## DELEGATED HOUSEHOLDER DECISION

TITLE: PROPOSED ELEVATIONS

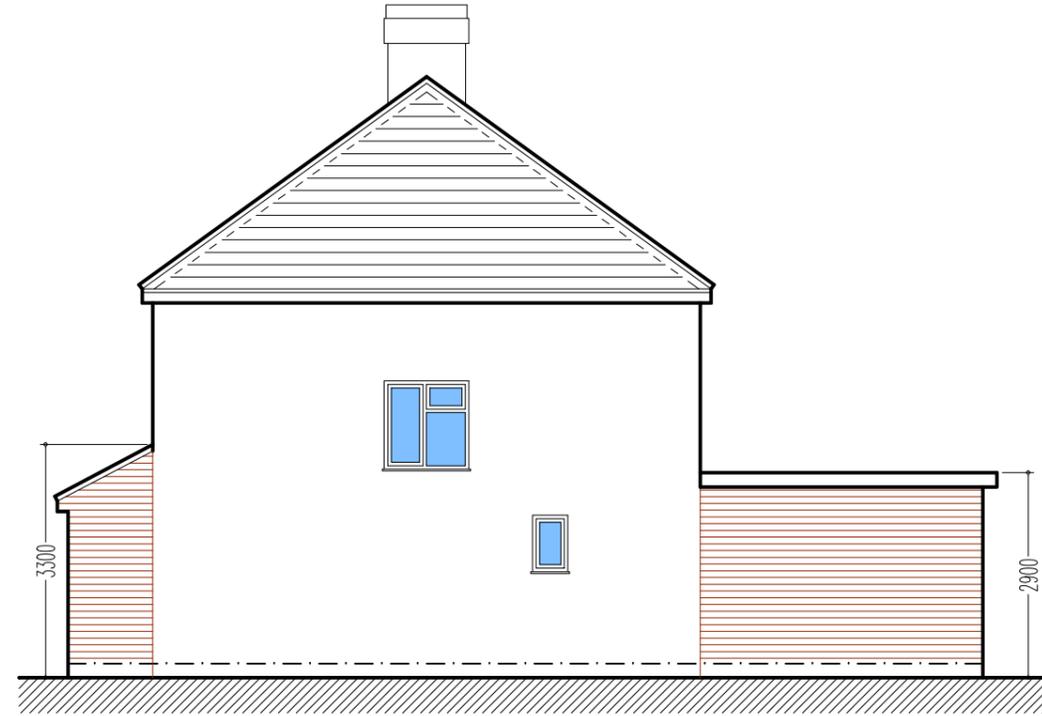
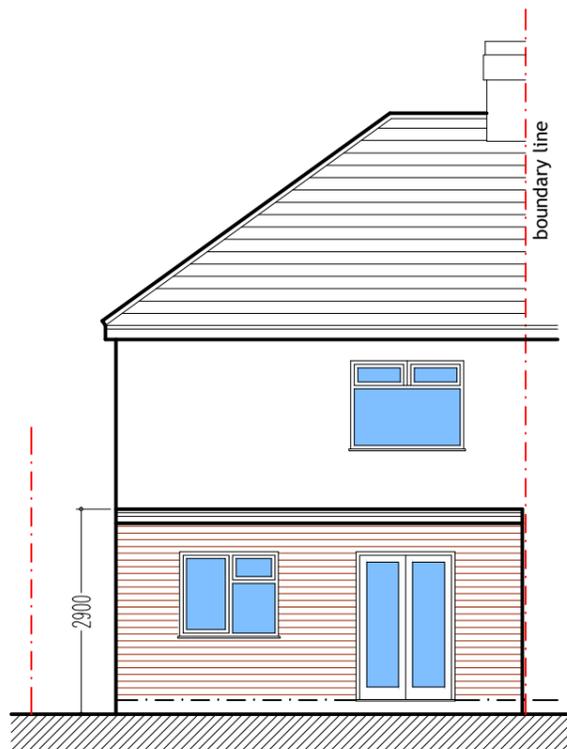
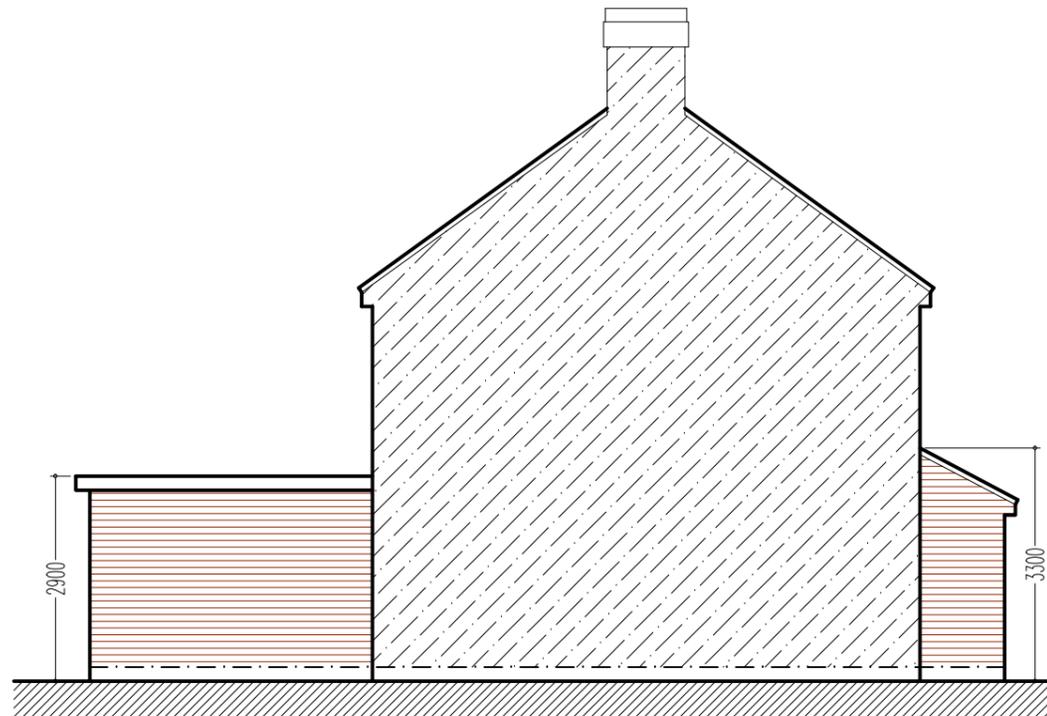
The proposed single storey rear extension would measure approximately 5.75 metres wide and 4m in depth from the rear wall of the property. The extension would have a flat roof with a height of approximately 2.9m . Whilst the depth is slightly beyond the prescribed measurements set out within DMHD 1, the additional depth is modest and would appear a domestically scaled addition to a domestic property. Overall when compared with the host dwelling the rear additional would appear subordinate and a proportionate extension. Having review the planning history of the surrounding properties it is clear that there are examples of rear extensions which have breached what would have been a uniformed rear building line. It is noted that the extension would extend marginally beyond the rear addition of the neighbouring dwelling which when taking into consideration there are a plethora of rear extensions within the immediate context of the development which have varying depths, the proposal would not appear out of character and would not significantly detract from the established pattern of development within the area.

The front porch is proposed which measures 1.2m in depth, 2.4m in width and 3.3m in height. This element appear subordinate and is acceptable in design and compliant with Policy DMHD 1.

A condition is recommended to ensure the development is externally finished in materials matching those used on the original host dwelling.

TITLE: EXISTING AND PROPOSED PLAN

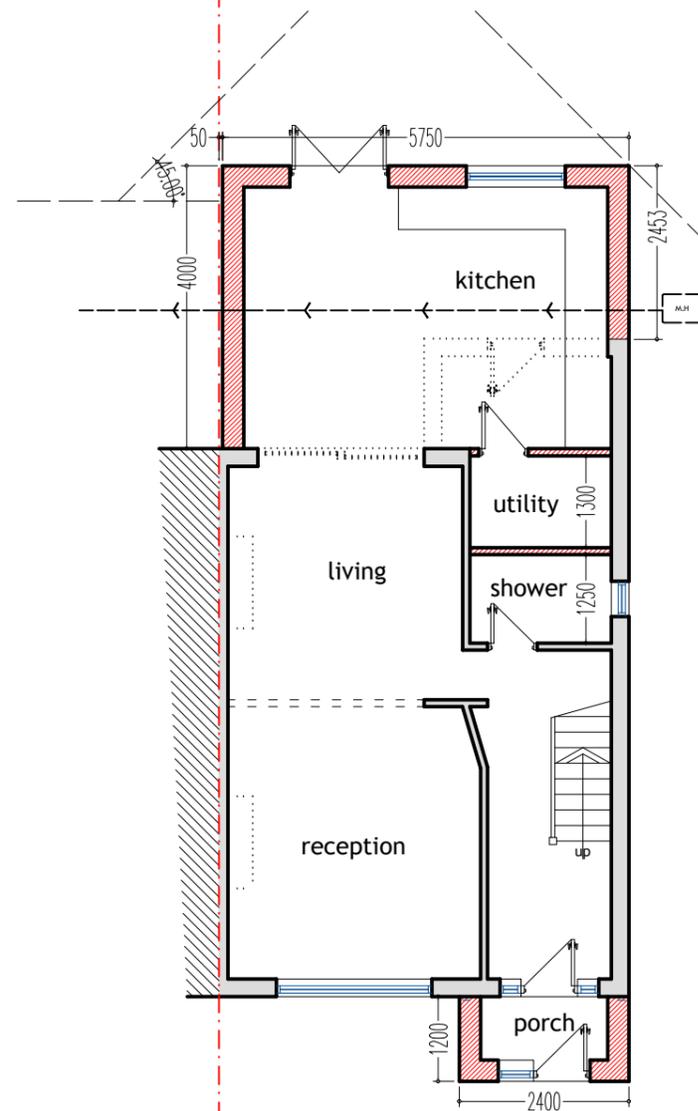
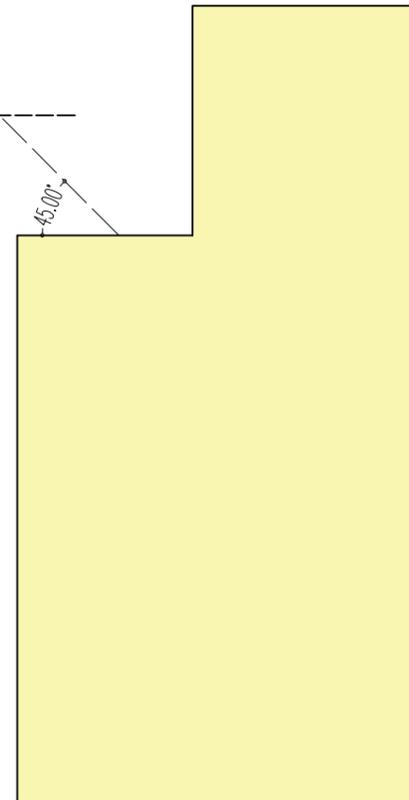
The application site adjoins Number 603 Field End road to the east. The proposed rear element would exceed the current wall of their rear element by only 40cm as such the proposal would not result in a level of overshadowing which would be considered harmful. Number 607 East End Road is located to the East, this property features a stepped rear elevation where the side elevation steps in towards the rear creating a half width outrigger to the rear of the property. However it is noted that there is a structure which is site on the boundary line which would result in a degree of overshadowing of any windows within the recessed section of the rear elevation during certain times of the day. The proposed extension is set sufficiently away from the shared boundary with this neighbouring property, it would feature a height of 2.9 m therefore reducing the level of potential overshadowing. The Applicant has provided a drawing which illustrates the 45 degree line drawn from the centreline of the nearest neighbouring habitable room window would not be breached. As such, despite there being concerns relating to overshadowing there this would be limited to an acceptable degree given that the extension is set away from the neighbouring property by approx 2.3 m, there roof height would be 2.9 and there is evidence that the 45 degree line would not be breached, the proposal would not result in a level of harm in terms of overshadowing or loss of outlook which would be great enough to justify refusal and withstand an appeal.

Given that no side facing windows have been proposed and the proposed rear windows would have a similar impact to existing ground floor windows it is considered that there will be no impact in terms of loss of privacy.

In terms the front porch, given the modest depth of 1.2m there seems to adequate space to manoeuvre and access the drive. This element is still located in the red line and footprint of the host dwelling and therefore the implications are considered minimal. Also, it is likely that a vehicle would park frontways and 'angled' to the left of the porch which would allow for a sufficient depth of
